Urban Design Review Panel Report

New Campus Development for
The Ottawa Hospital
Phase 4: Main Hospital Project
Ottawa, Ontario

March 23, 2026
(Issued for SPC Resubmission)
Prepared by bbb Architects Ottawa Inc.

END FACADE

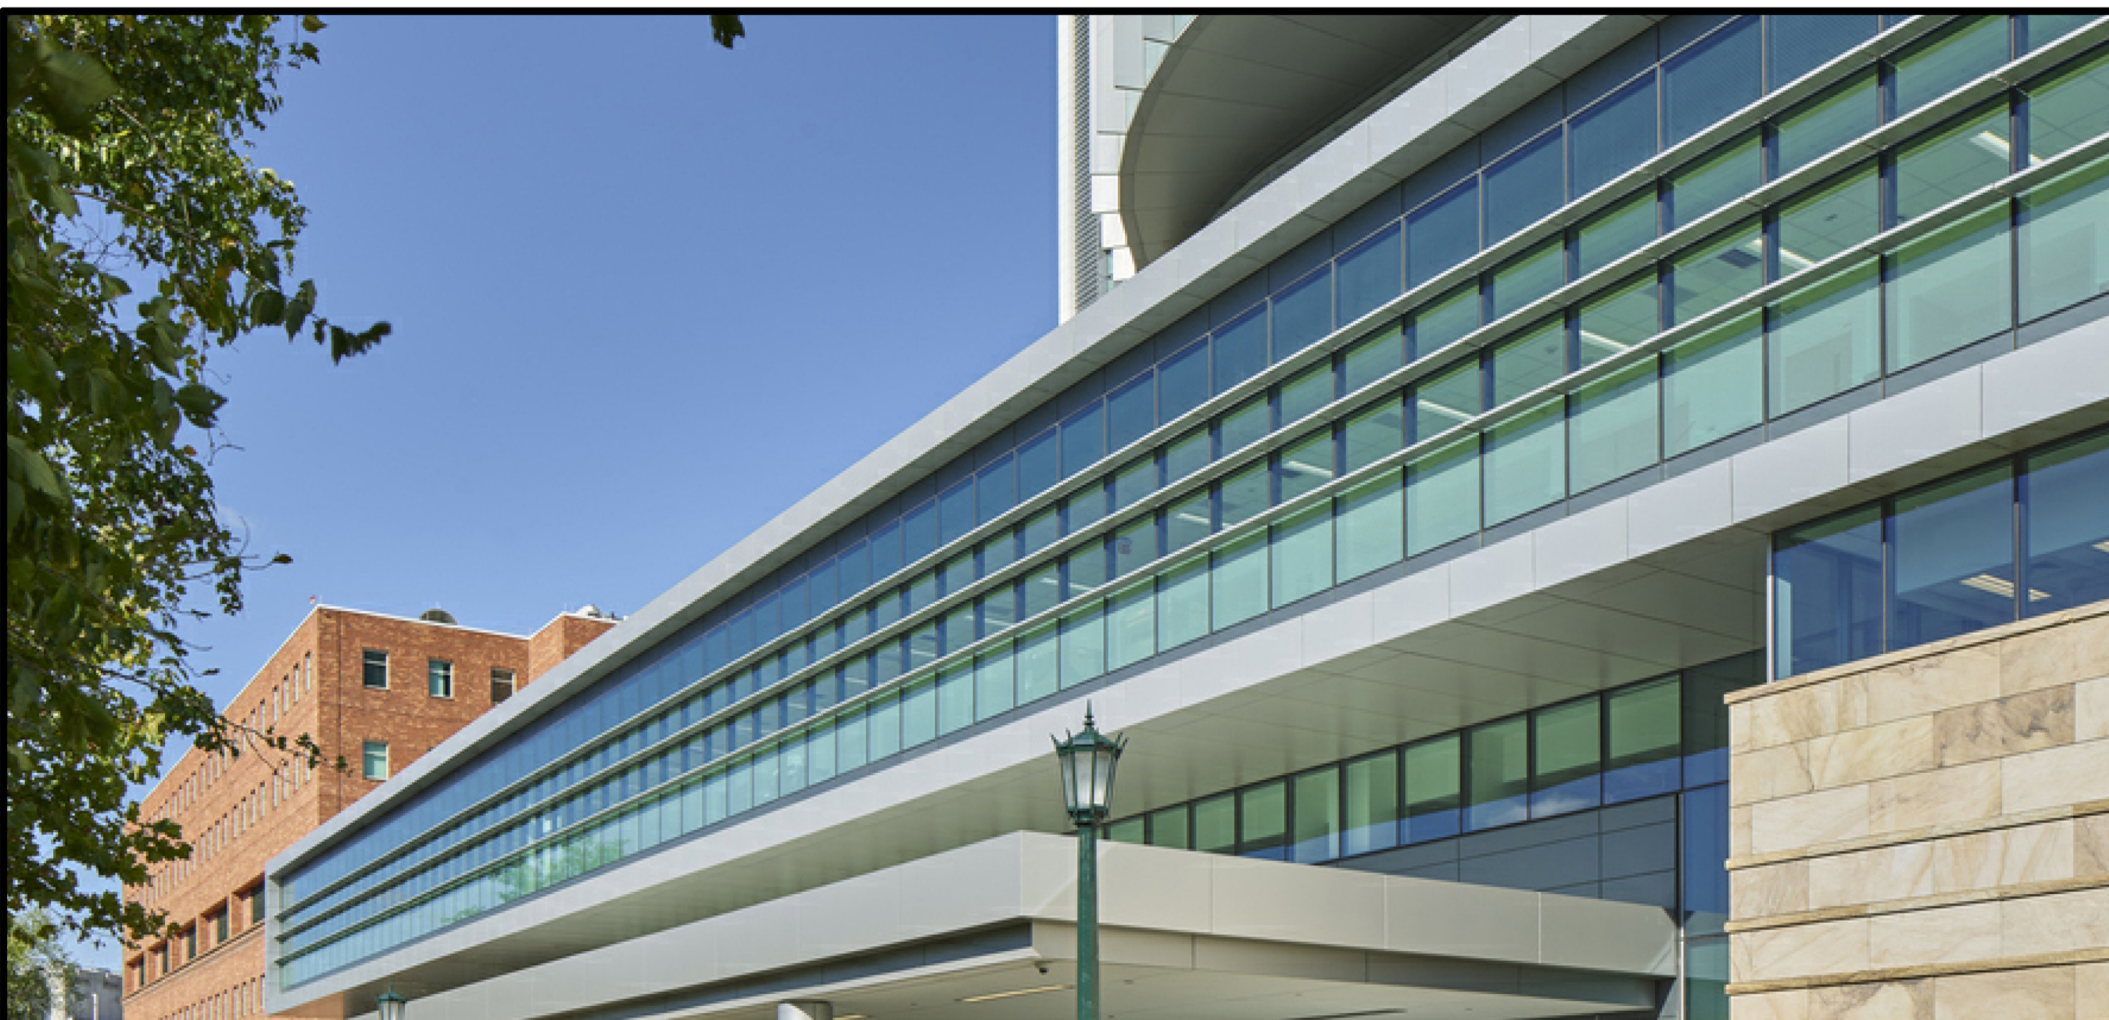
- The Panel recommends that the end façades of the patient towers maintain a simple and clear design strategy, ensuring consistency with the rest of the elevation treatments.

The overall architectural expression of the façades has been simplified by the refinement of the material selection as described in 2.2. For the tower ends, the design that was presented to UDRP included a horizontal expression of the Main Entrance framing façades in the centre of the towers. In response to the recommendation to simplify the façades, these tower ends were revised to instead wrap the Inpatient Room Façade expression around the corners. A simple glazed element extends vertically at the tower ends to relate to the expression of the tower hinges and express the circulation and corridors beyond.

SOUTH FACADE

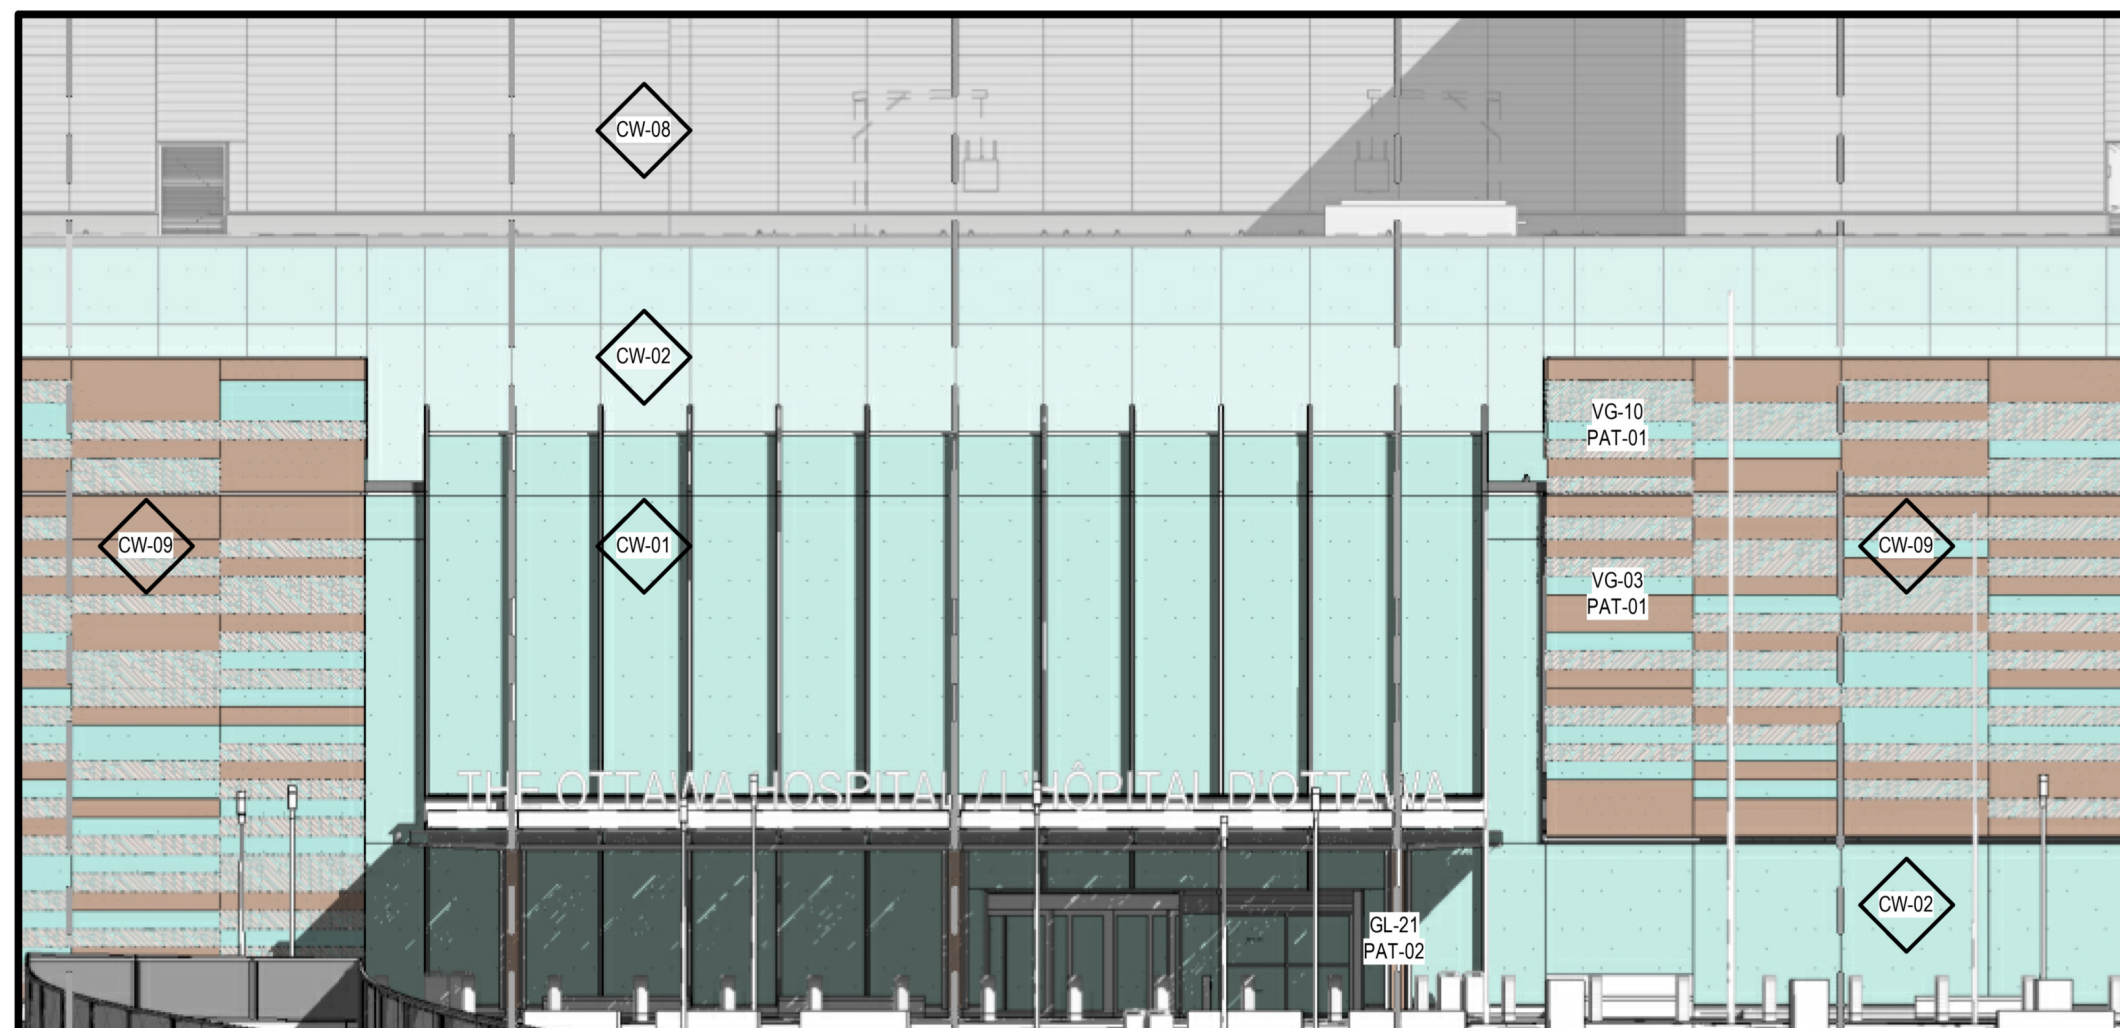
- The Panel recognizes that the south-facing elevation presents a design challenge due to its multiple programmatic requirements, however the variety of façade treatments appears overly complex.
- The Panel recommends simplifying the façade treatment by focusing on one dominant element, such as the canopy, and reducing the number of treatments and creating a quieter expression for the other elements.

For the south façades, the same simplification of tower ends that is demonstrated in 5.1 was included at the south as well. To address the recommendation to focus on dominant elements, the surgical corridor on Level 3 and the Emergency corridor on Level 0 are expressed as strong horizontals within the composition. The cedar medicinal plant motif and custom digital frit have been extended to Level 0 to improve the legibility of the Emergency corridor and

introduce warmth in the pedestrian zone. The remainder of the functional elements on the south, including exit stairs, have been downplayed with simple and minimal detailing and expression.
